Letter No.B3/3786/2018 , Dated: 24.07.2019

Sub: CMDA – Area Plans Unit - ‘B’ Channel (North) - Planning Permission Application for the re-construction of 2 Blocks Ground Floor +3 Floors Residential Building with 80 dwelling units at S.No.263 part, Sadayankuppam Village in Block No.83 of Manali New Town – Remittance of DC and other charges – DC advice Sent – Reg.

SCALE	PROJECT	MANALI NEW TOWN PHASE - I : (POCKET-5)
1 : 400	DWG.TITLE.	SITE PLAN
SIZE	DWG.NO. TNSCB/DP/13784/2015/ SITE PLAN REV. 01	
A0

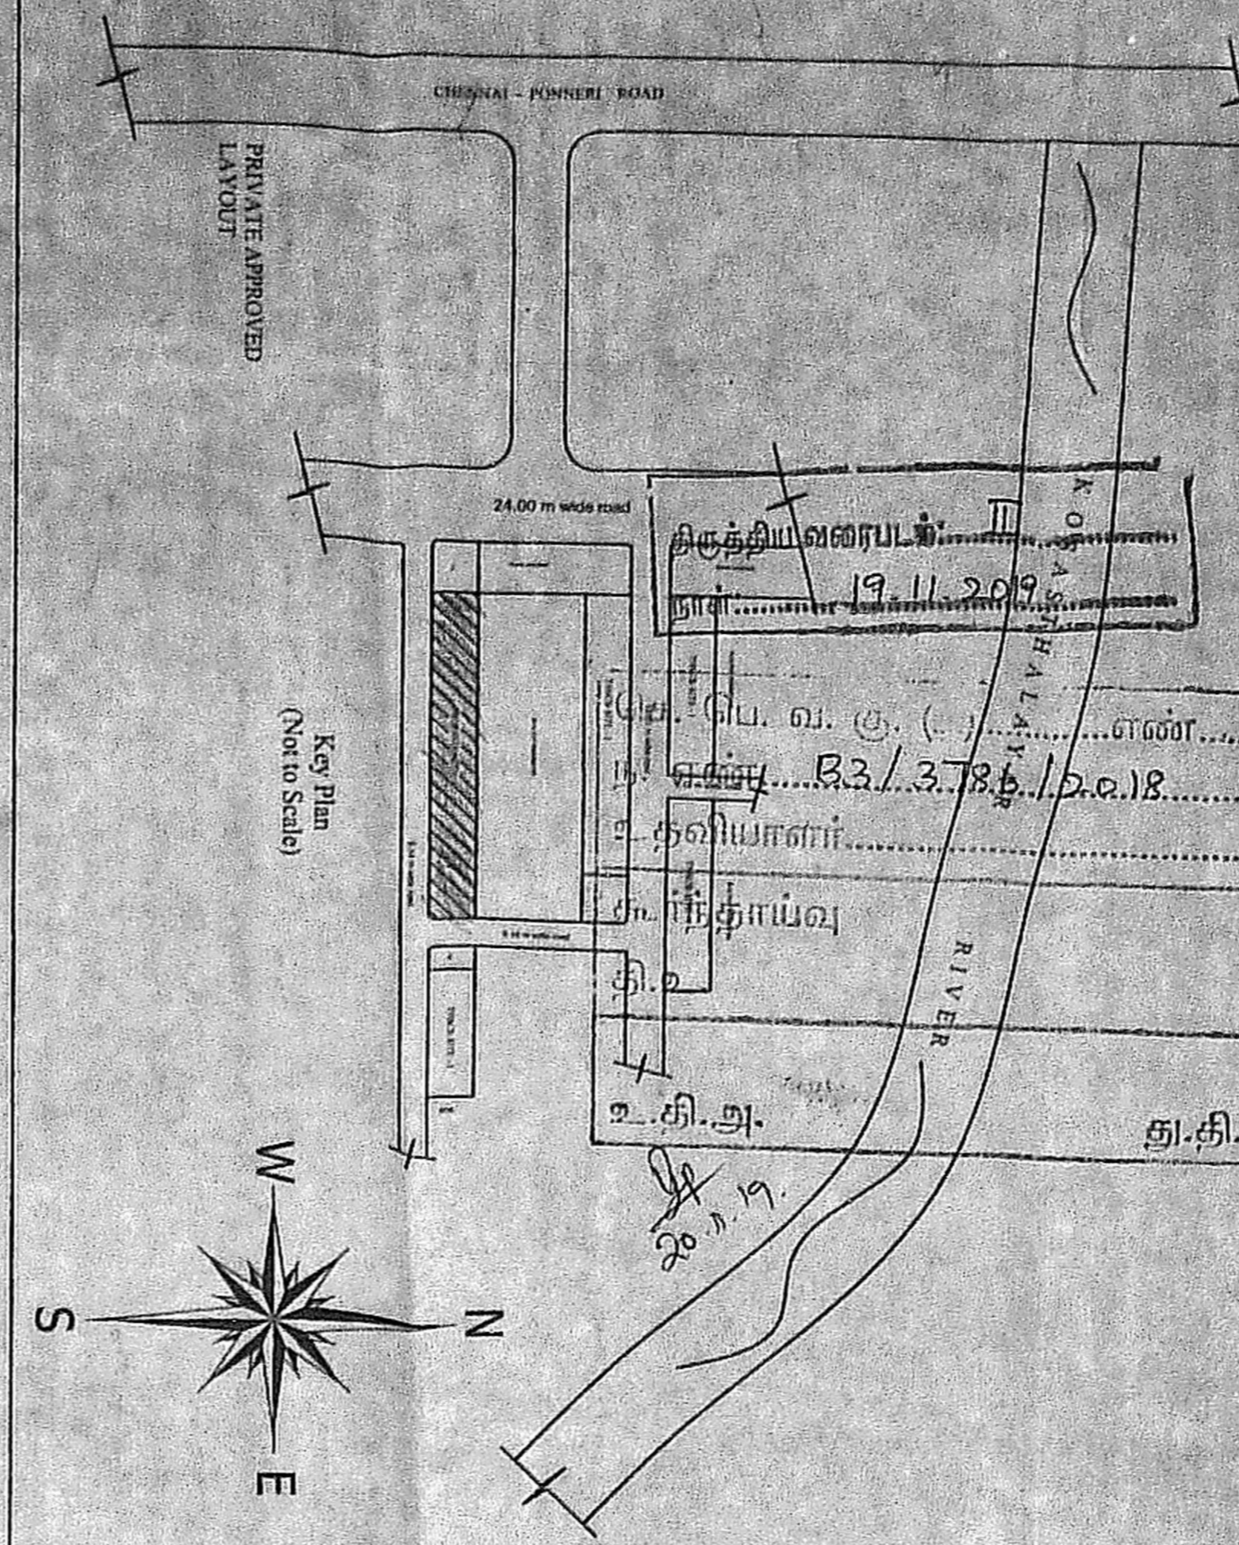
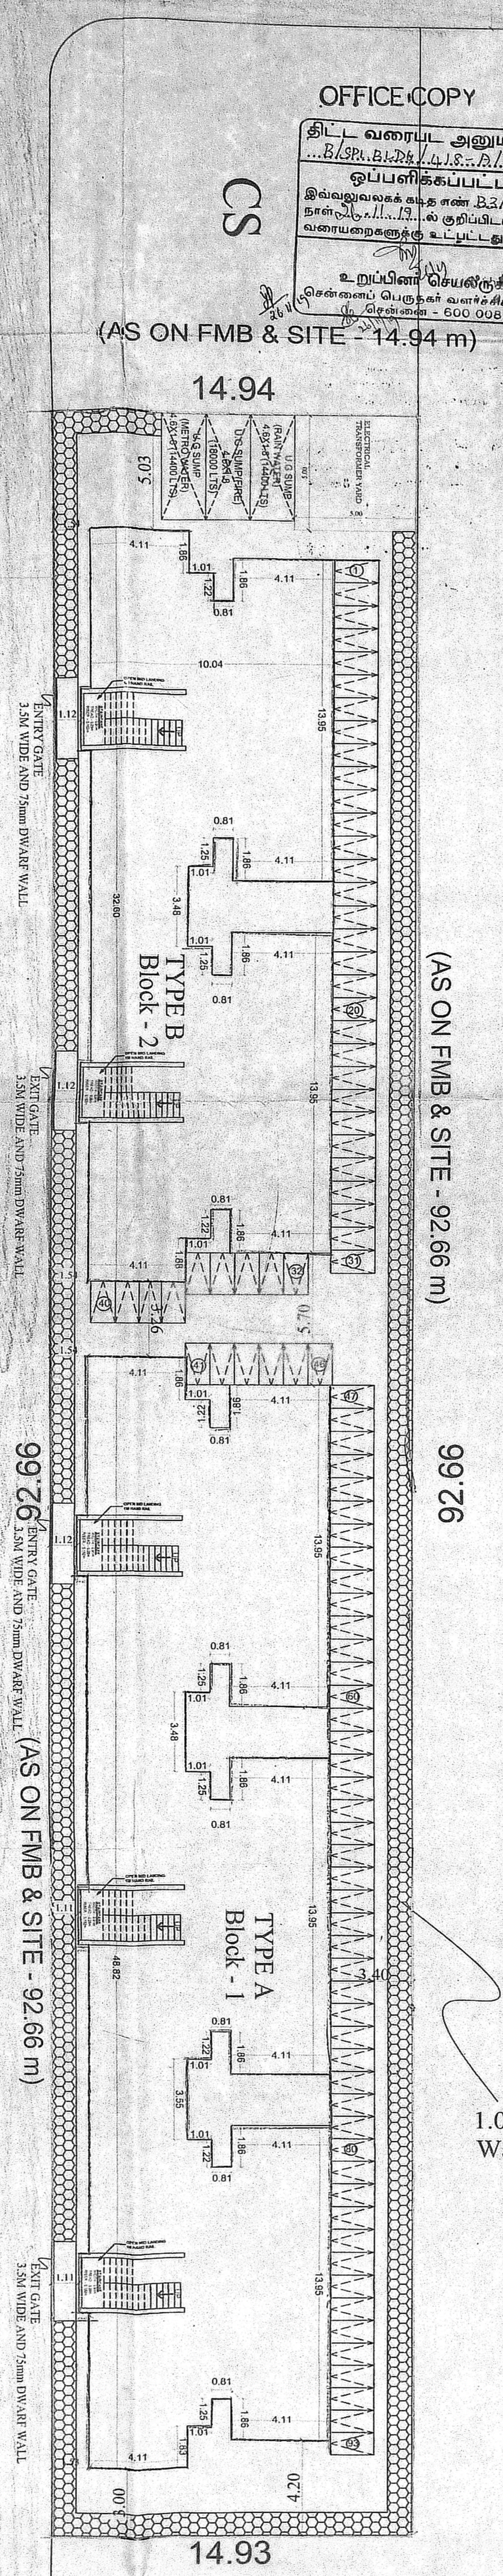
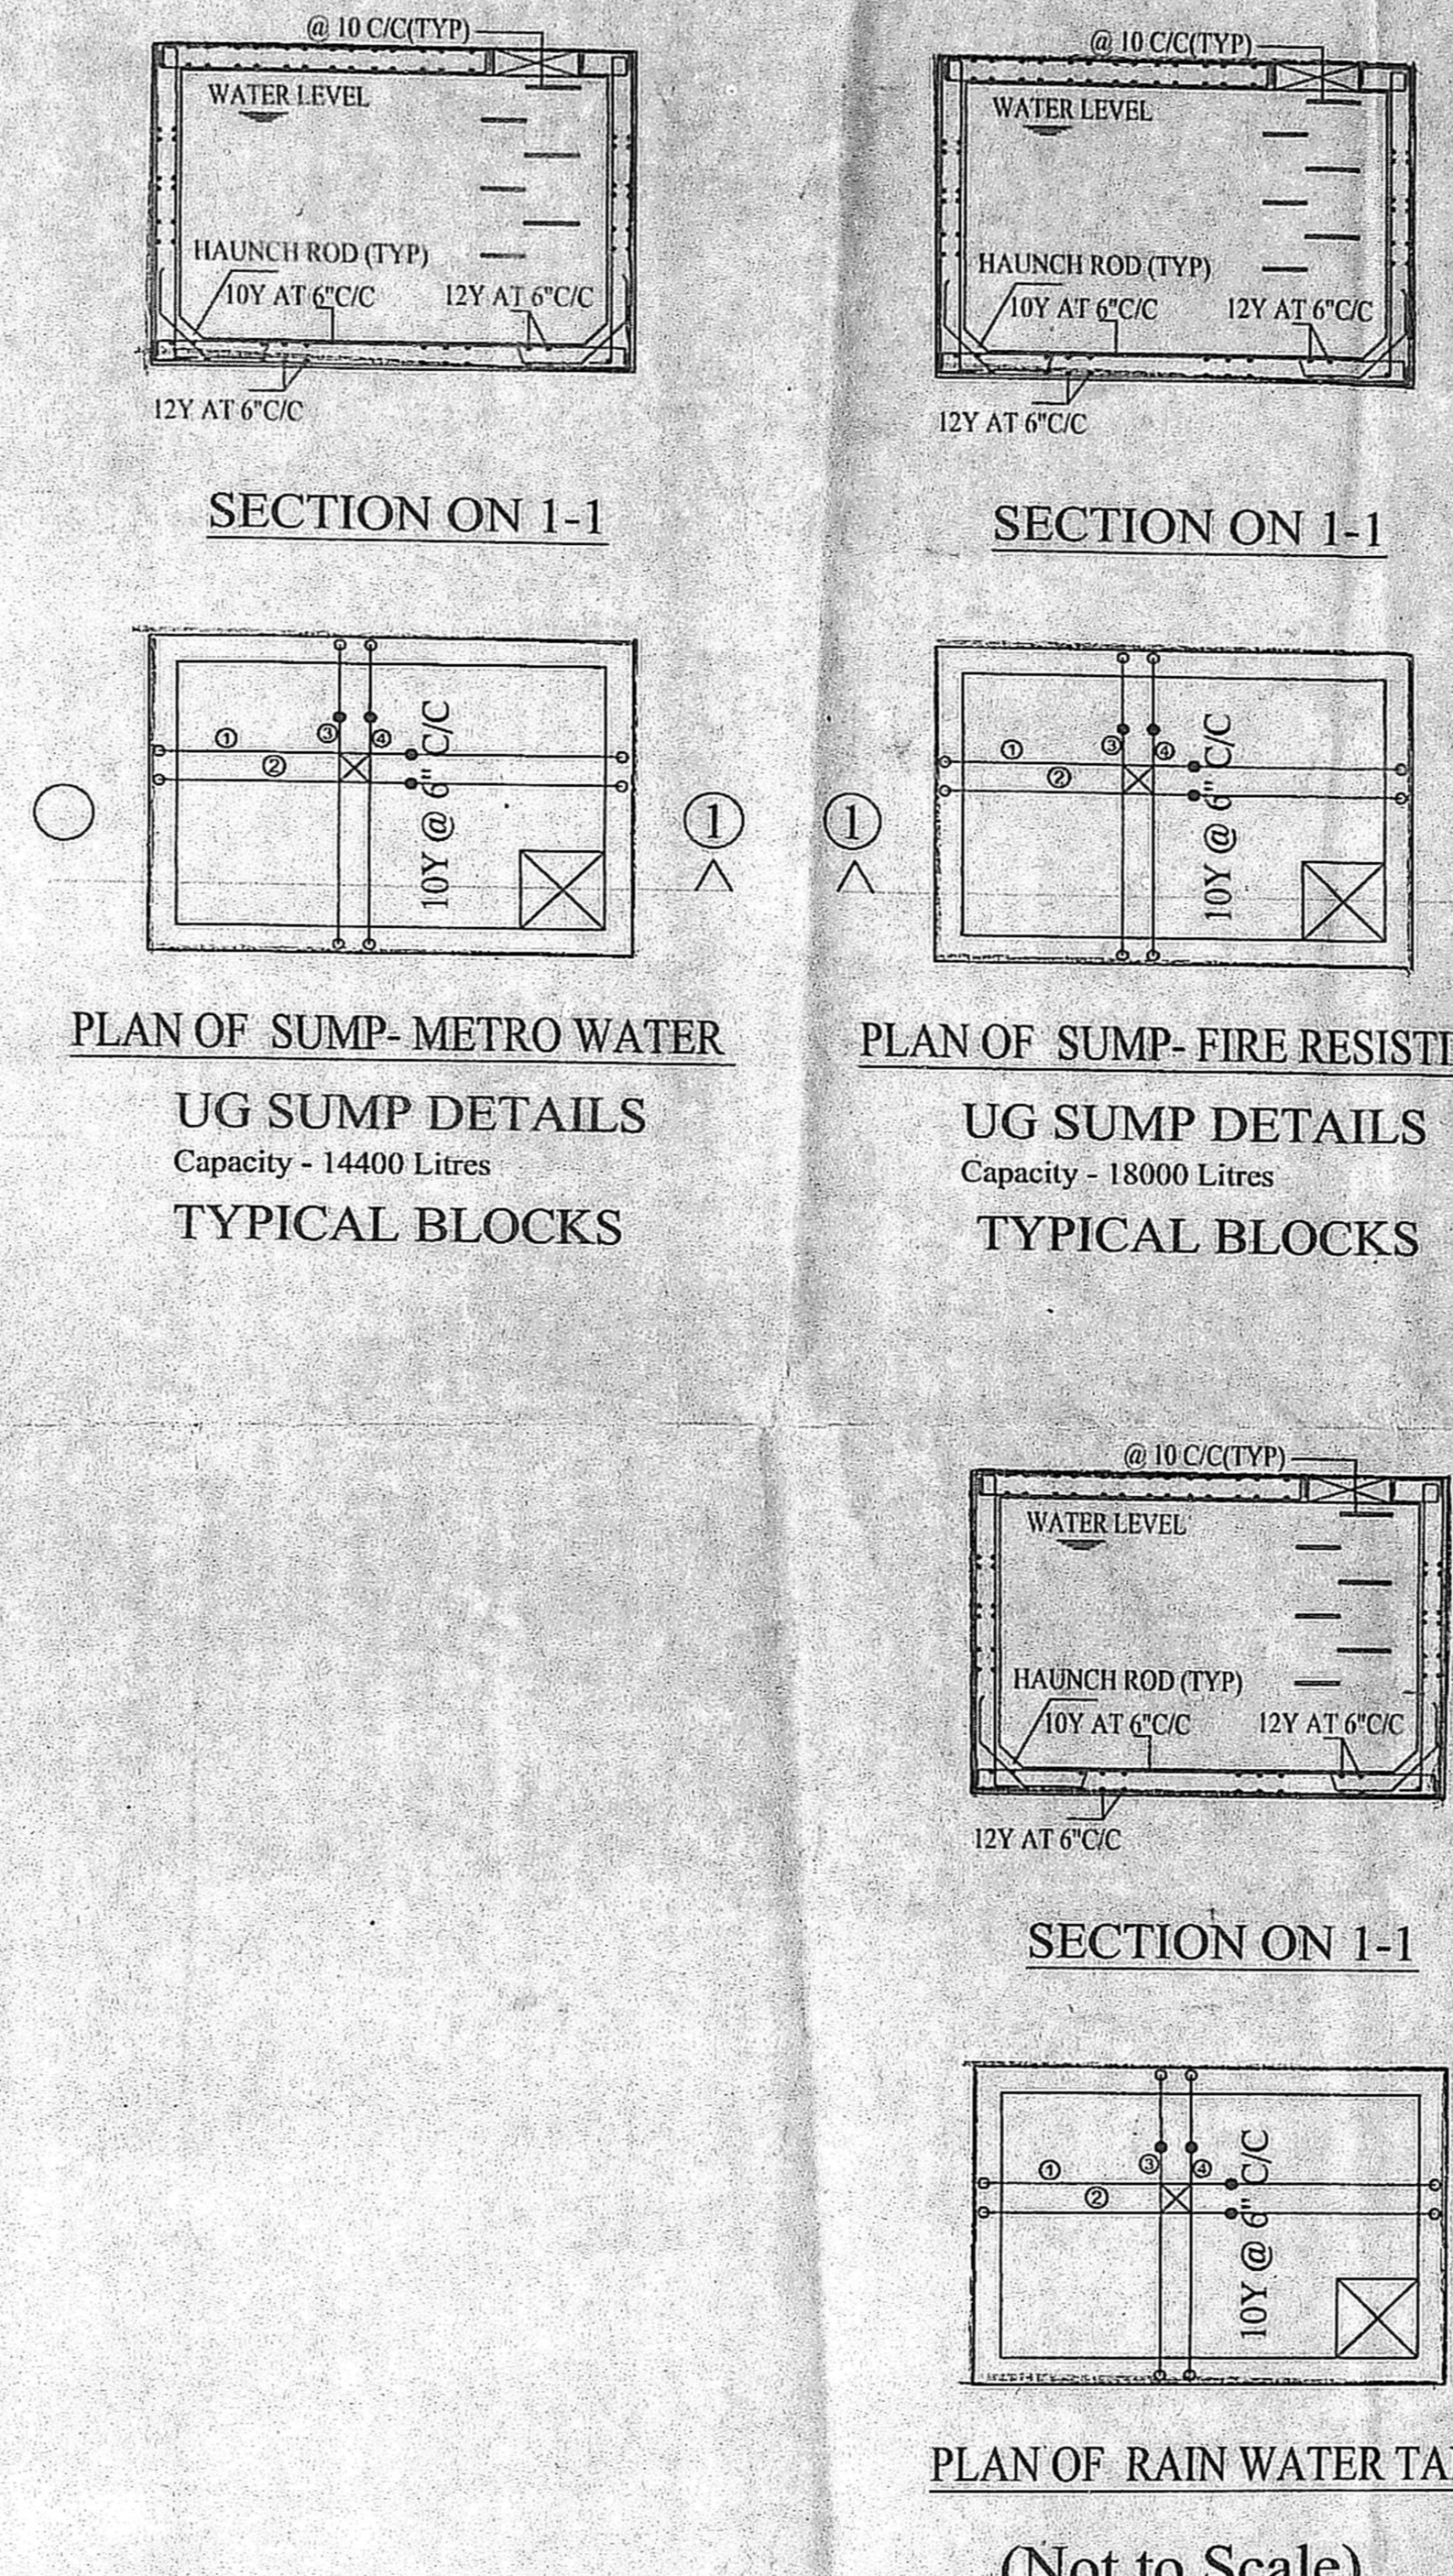
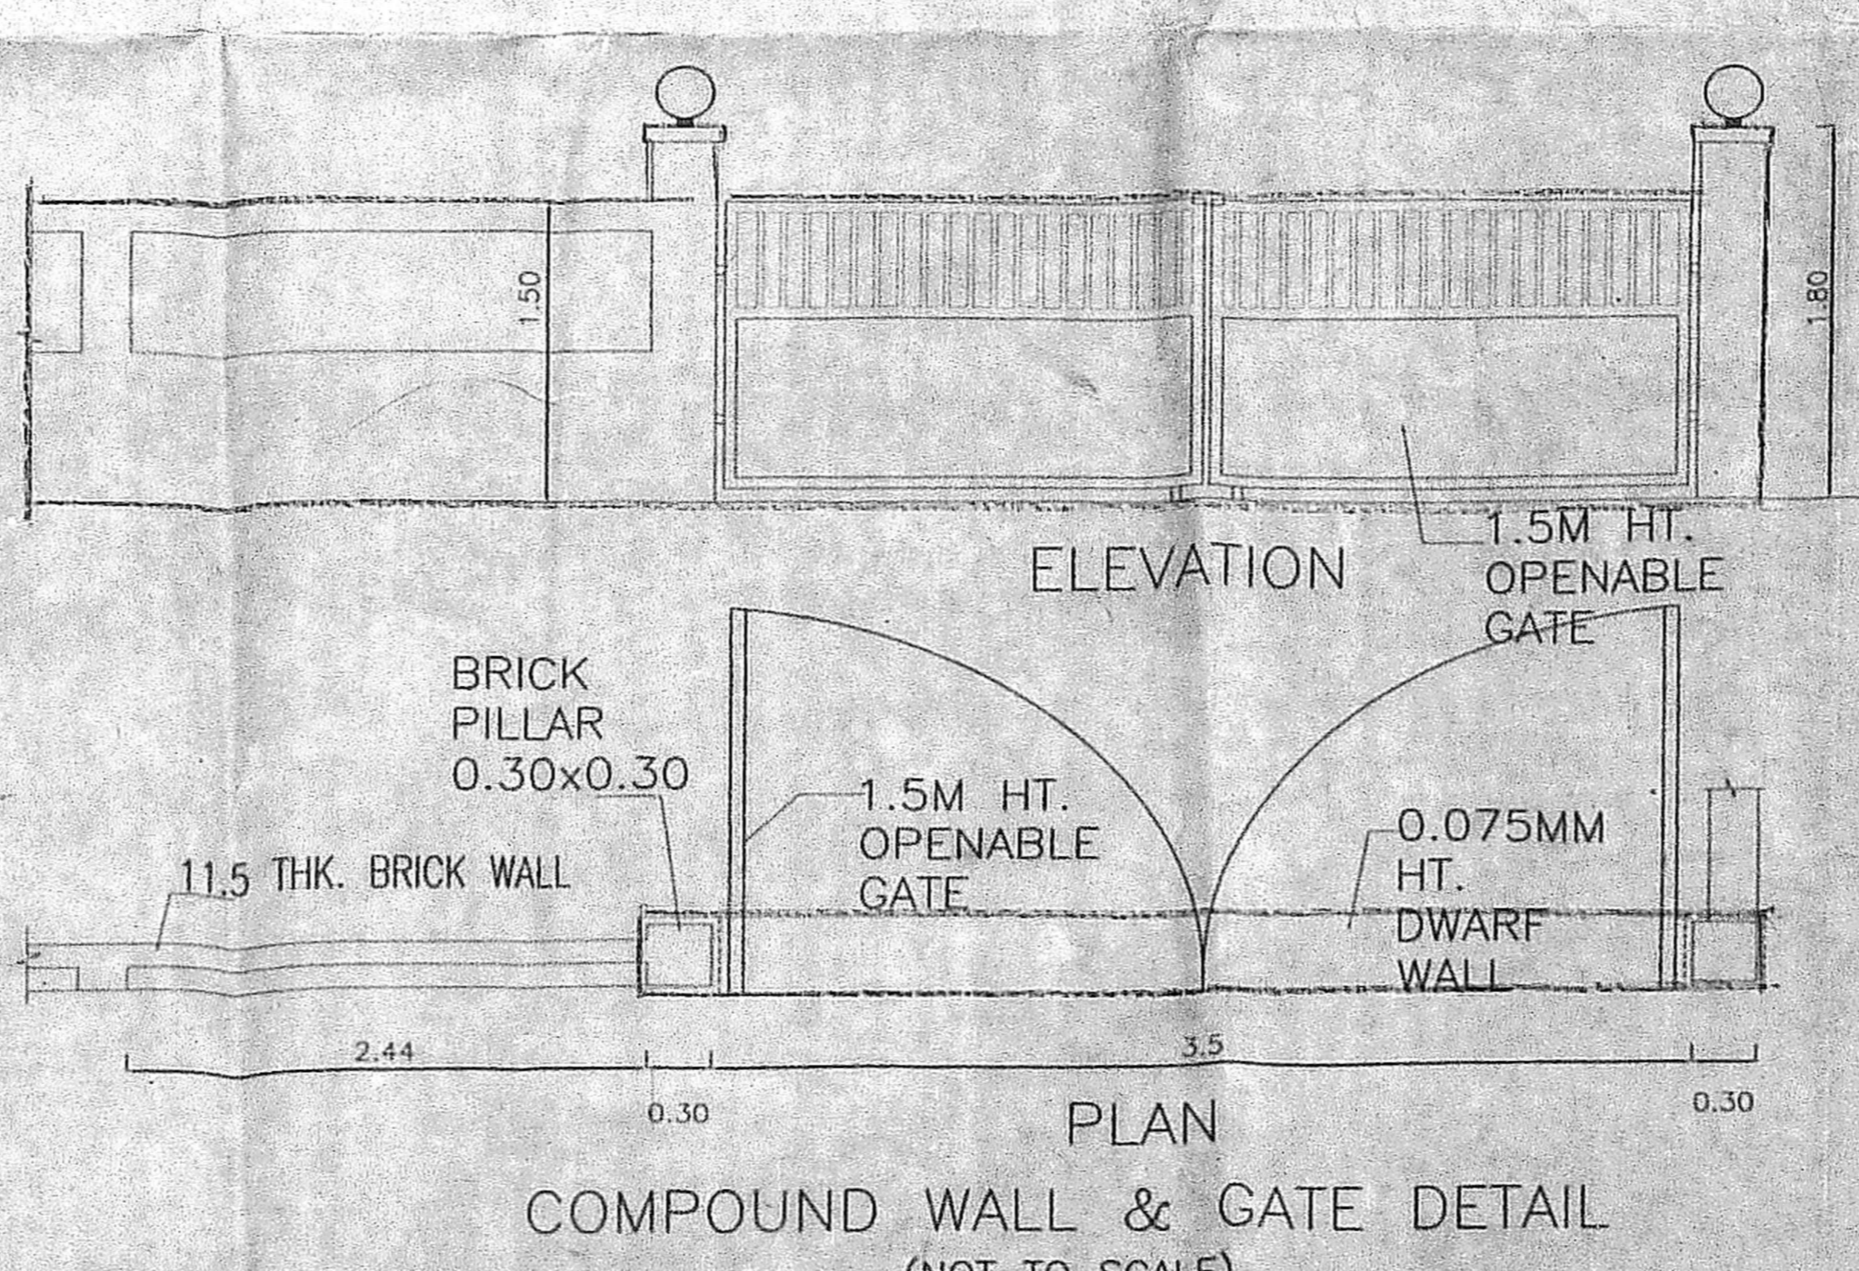
7. You are requested to furnish the following particulars and 5 copies of revised plan rectifying the following corrections:
- a) Open Transformer yard to be shown in the plan.

- b) 88 nos. of Two Wheeler partaking to be shown.
 - c) Site boundary measurements on eastern side to be shown correctly in the site plan.
 - d) The building breakup measurement do not tally with overall measurement.
